Your Ref: OWPC25489
Our Ref: AW/343/19/T
Please ask for:
Lynnyrd Wolfe

Town & Country Planning Act 1990 (as amended)
Town & Country Planning (Tree Preservation) (England) Regulations 2012

Fell 4 No. Sycamore trees.
149 Barrack Lane Aldwick

REV	DESCRIPTION	DATE
PROJECT 149 BARRACK LANE ALDWICK WEST SUSSEX		
CLIENT R NIELD & J CAKE		
DRAWING TITLE LOCATION PLAN, BLOCK PLAN AND SITE PLAN		
SCALE VARIOUS @ A2	DRAWN BY MJW	DATE DEC 19
DWG NO 853/PL03	REV./

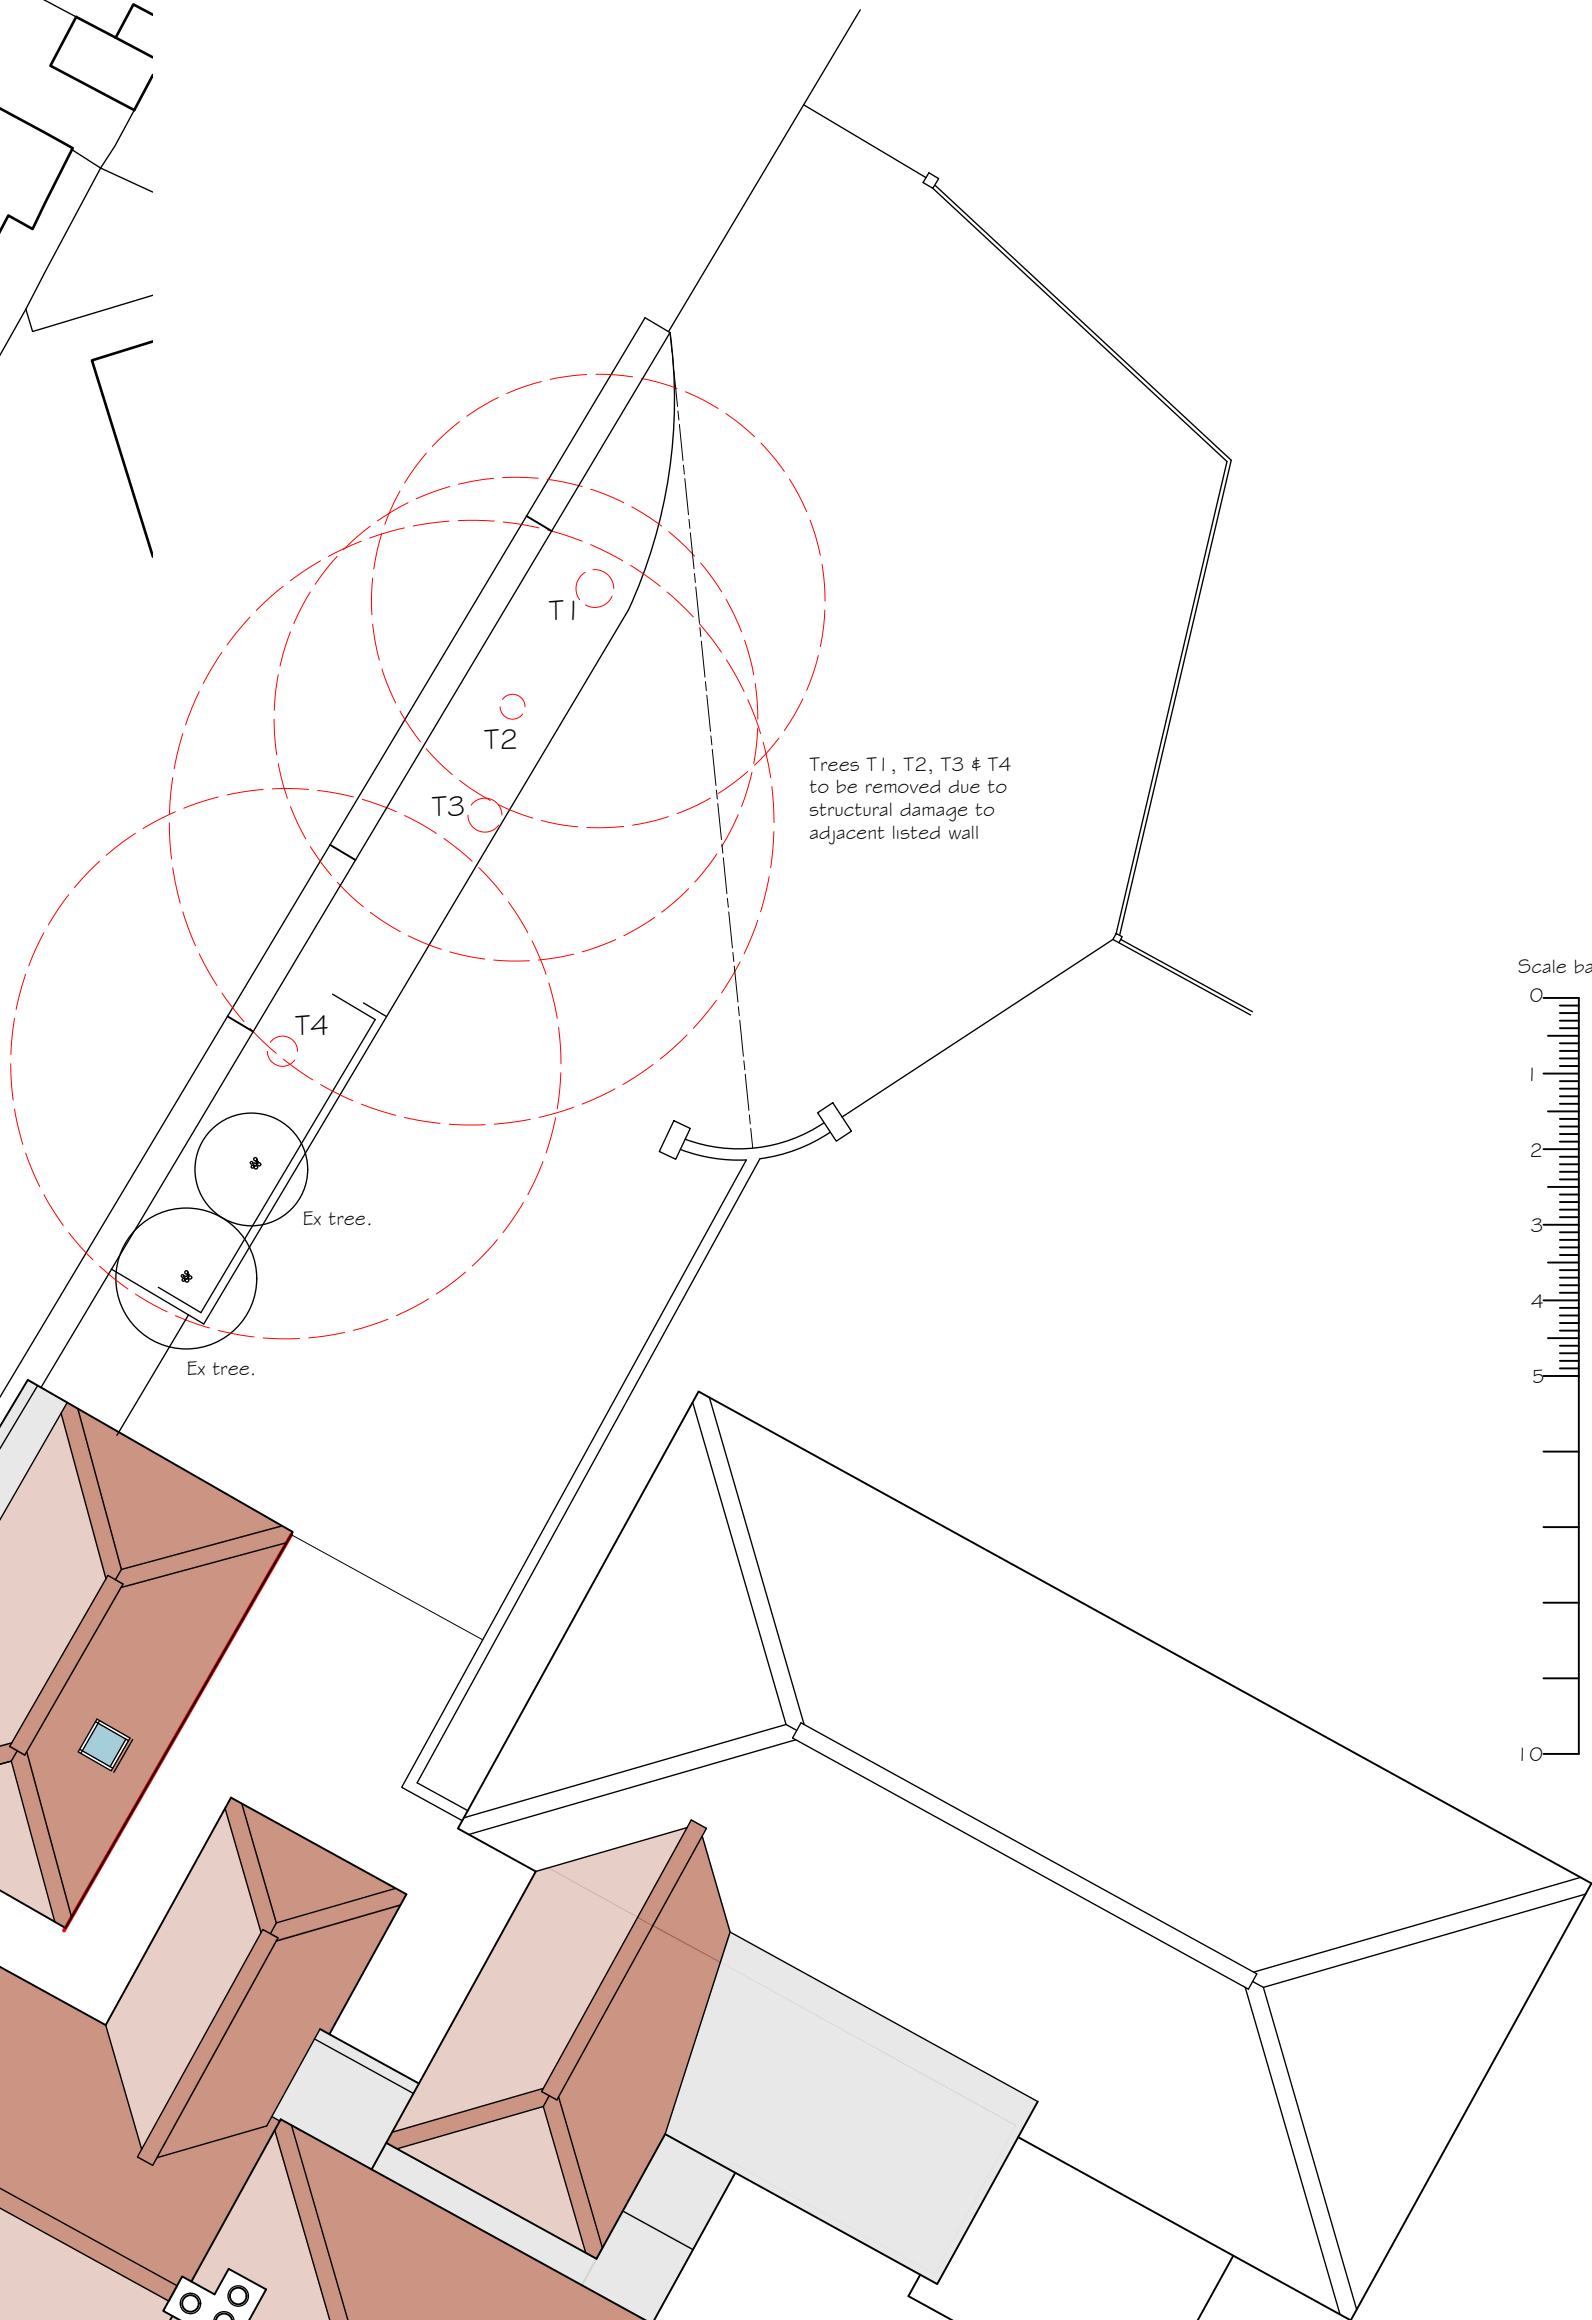
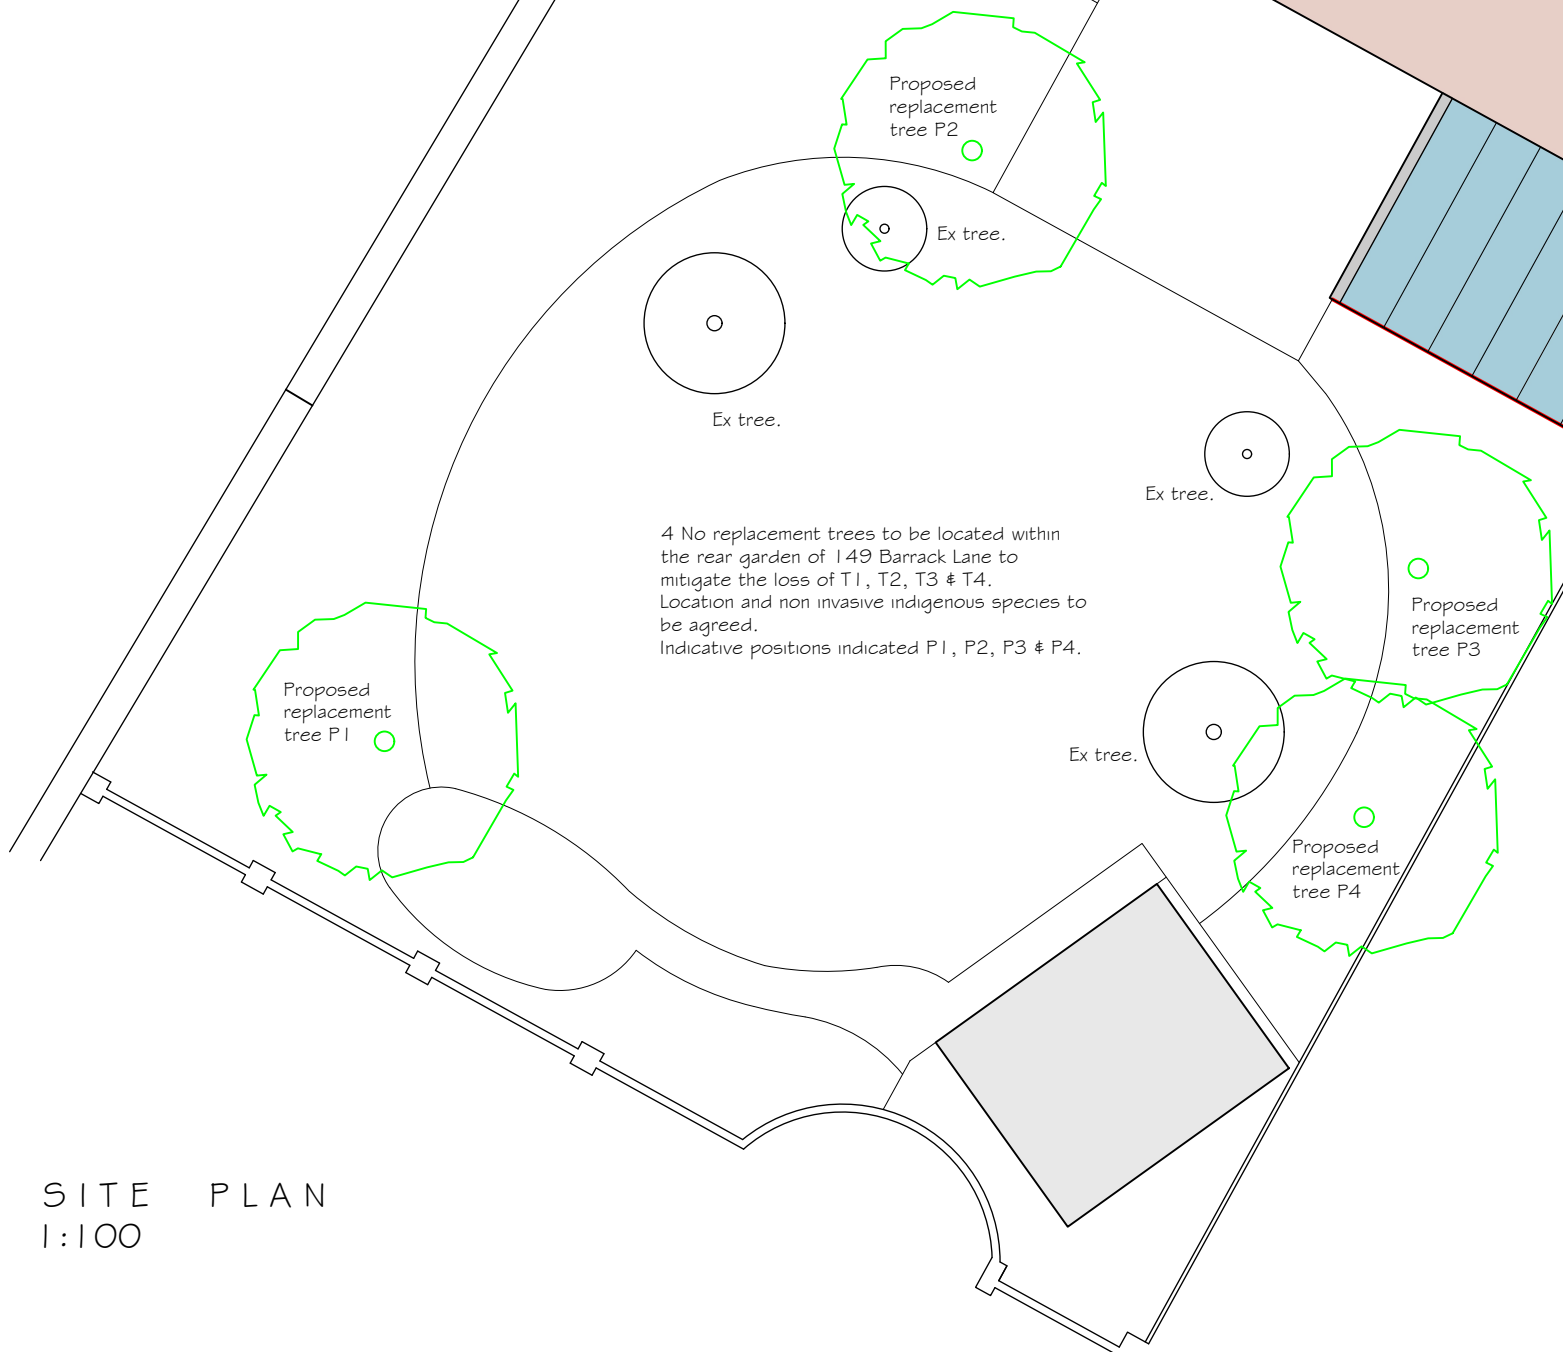
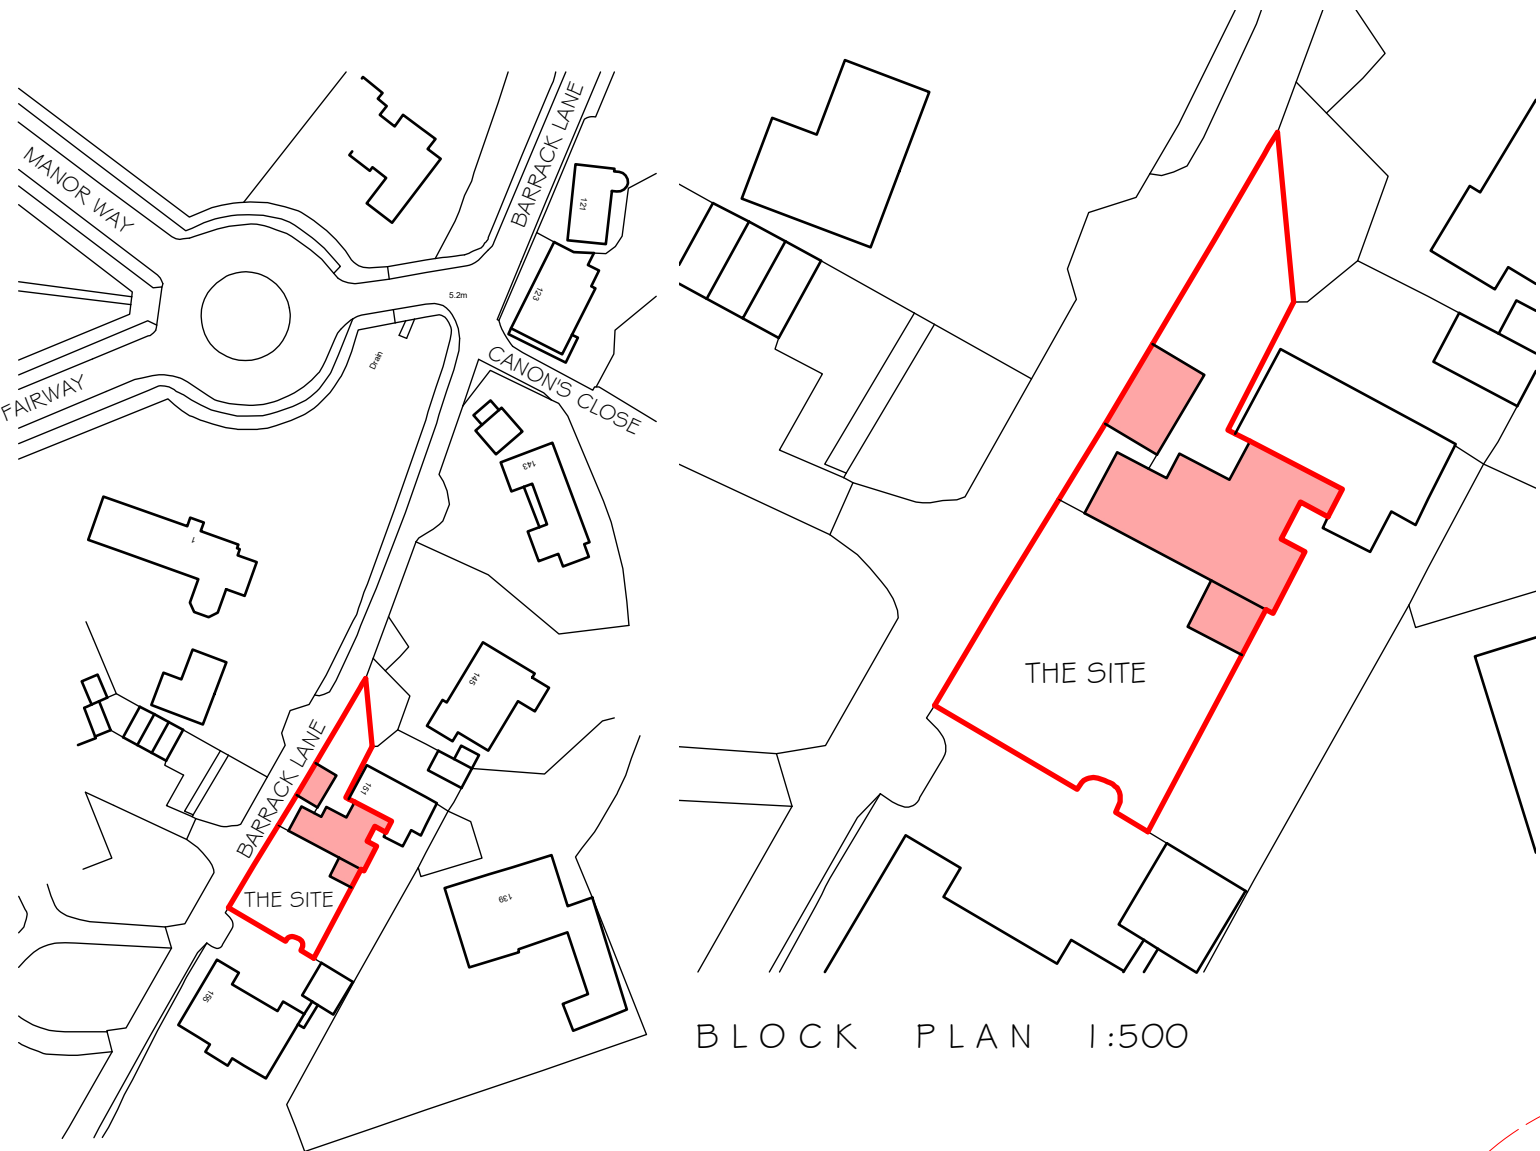
Members agreed that the Arun Arboriculturist be consulted regarding the application and that his decisions/recommendations be applied. However Members stipulated that if the trees are felled and in order to prevent damage to the wall that no digging and/or excavation machines should be used and they expressed the hope that the trees be replaced with suitable alternative varieties planted at a reasonable distance from the wall.
